Engineers Comments Regarding Surface Water Drainage

Application Reference:	LU/252/25/RES	Reviewer Reference:	ADC/EXT2/D213491
Planning Officer:	Hannah Kersley	Date of Review:	16.02.2026
Site Name:	Hampton Park Littlehampton		
Application Description:	Approval of reserve matters following LU/47/11/ (as amended by LU/182/15/) for the remaining open space elements including playing pitches, changing rooms, car parking area, northern allotments and the eastern extent of the Black Ditch Open Space.		
Assessment Number:	1 of 2

LITTLEHAMPTON PHASE 6
PLAYING FIELDS
PROPOSED FLOODPLAIN IMPACTS

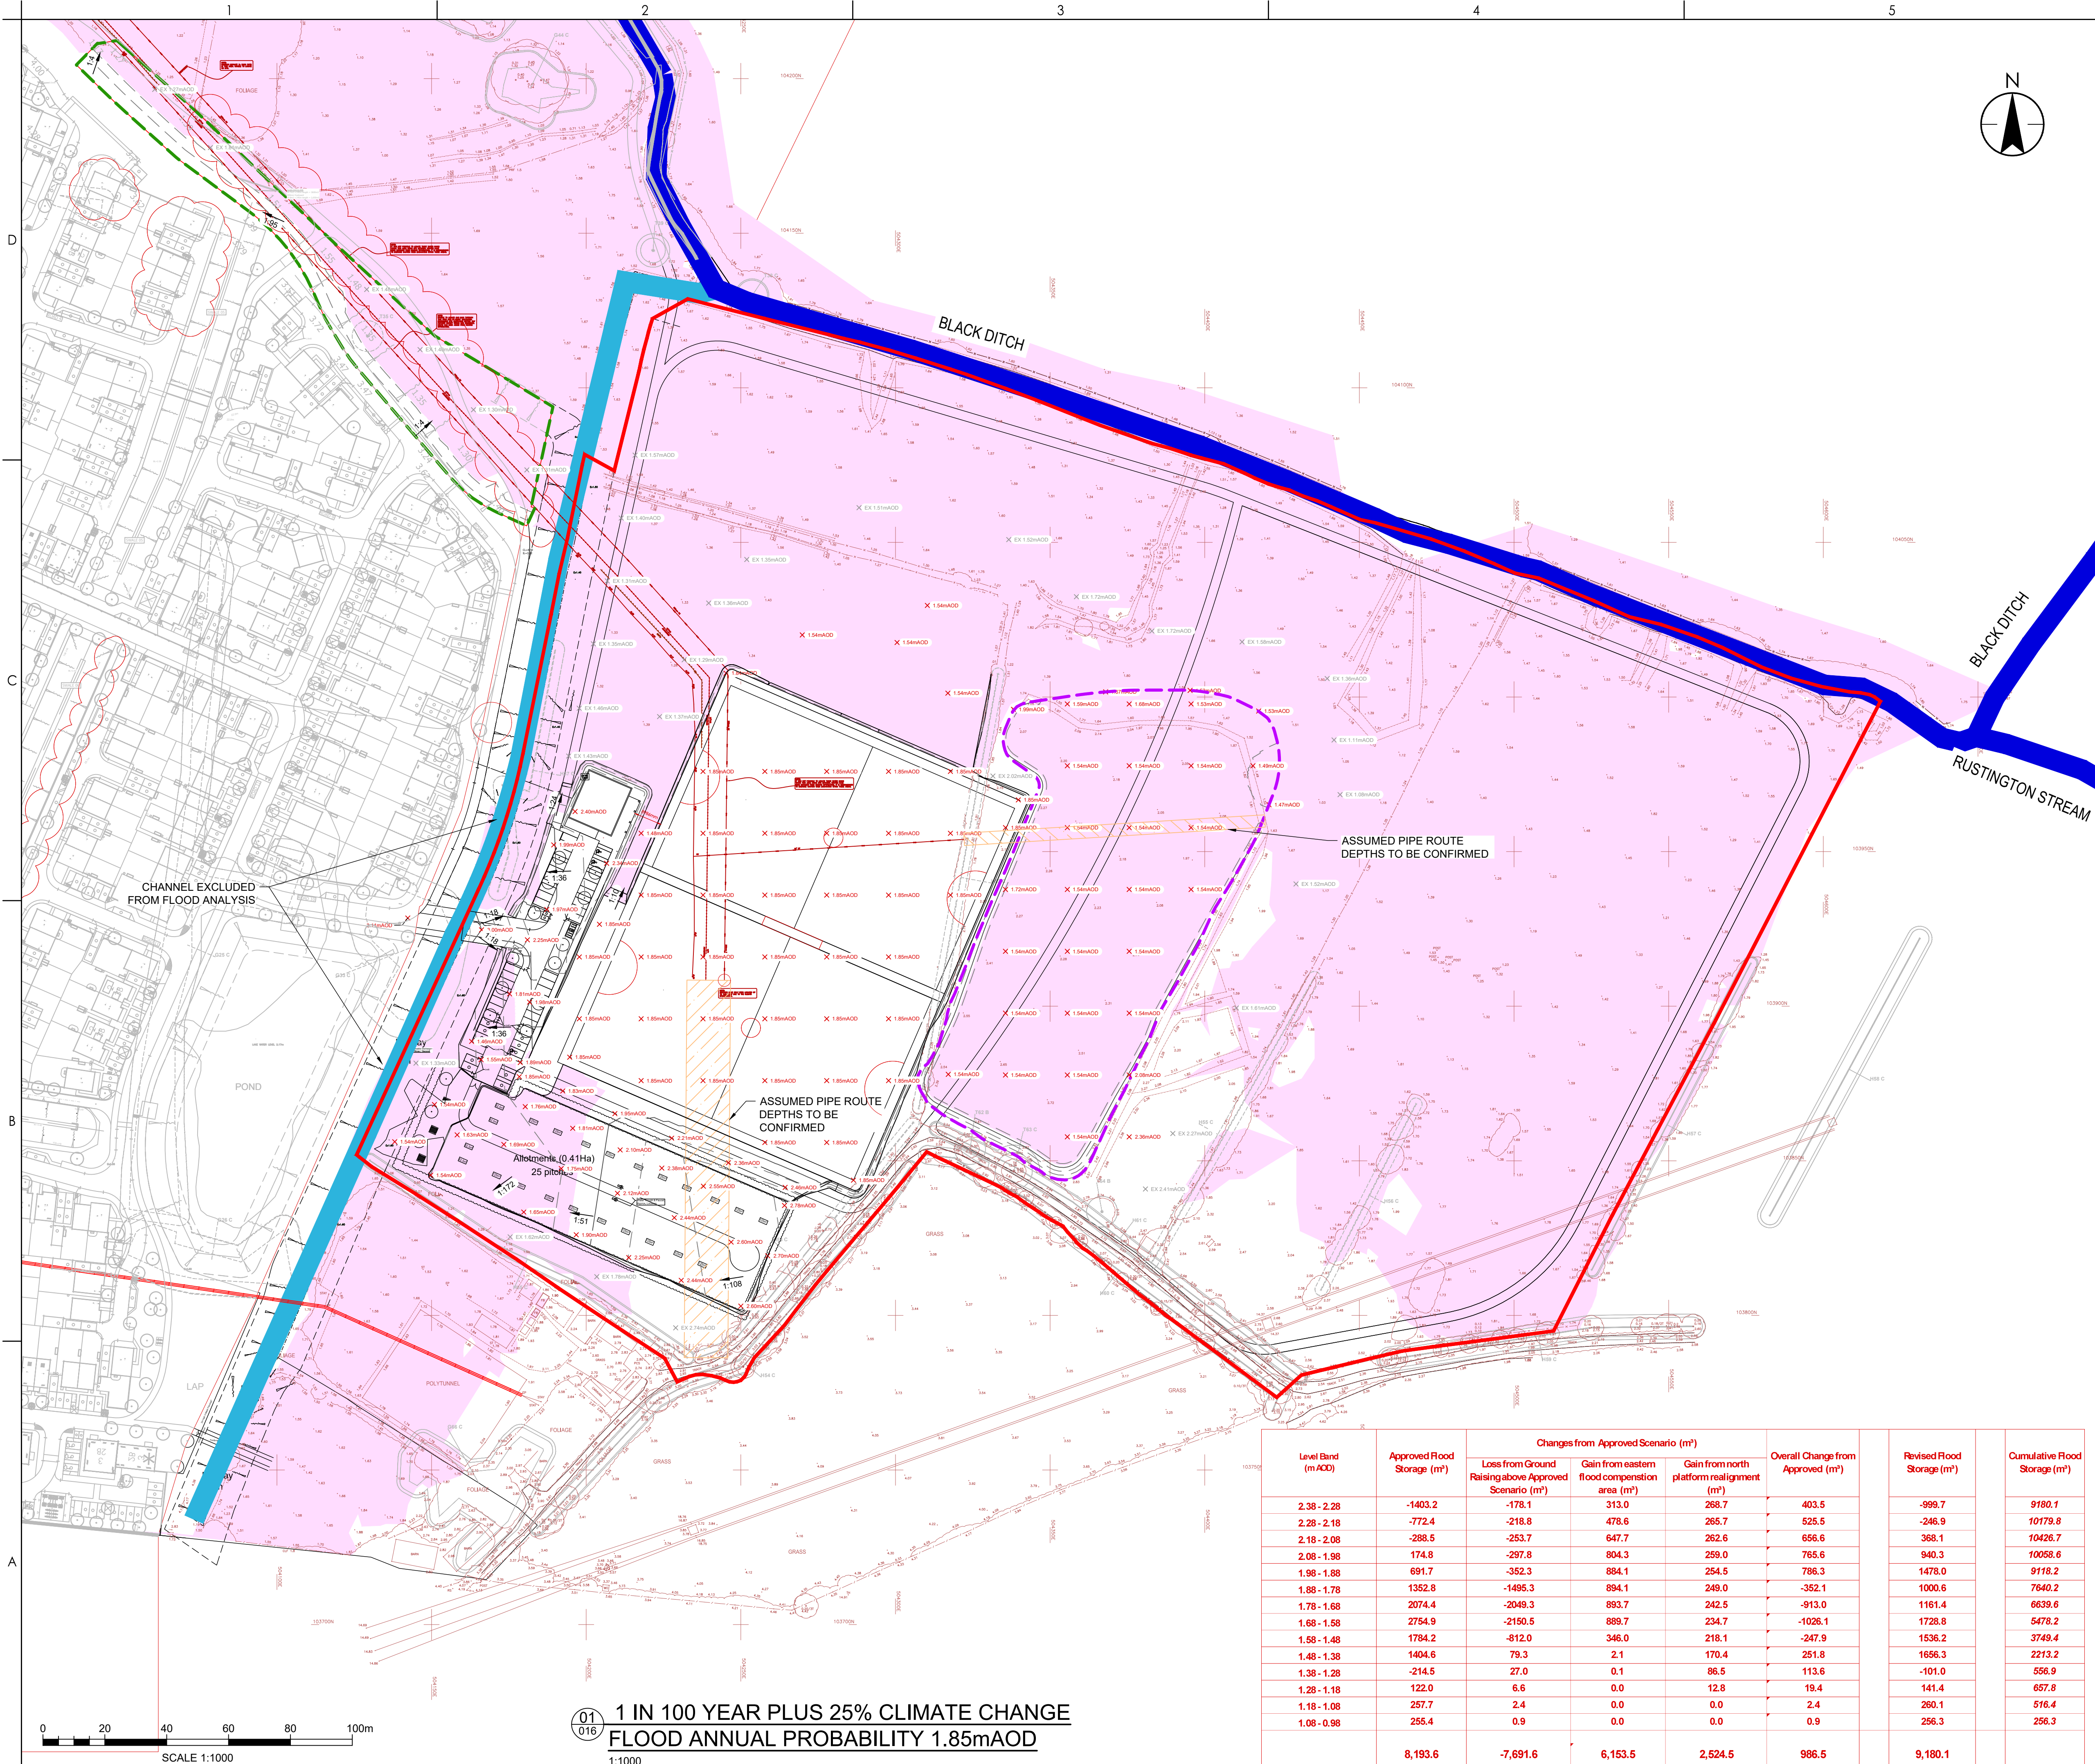
- 3.1. It is acknowledged that the findings of the Stantec report are adhered to where the playing fields will be elevated to 1.85m to comply for the 100year plus 25% climate change scenario.
- 3.2. Please provide 1D calculations for the independent surface water network for the playing fields area. This shall include a surcharged outfall. Noting the design criteria has been agreed previously, please ensure the latest FEH22 data is used for simulation. The WinDes calculations in appendix K are not acceptable; these must adhere to FEH22, CV=1 (both summer & winter), MADD factor = 0, runtime 1440mins.
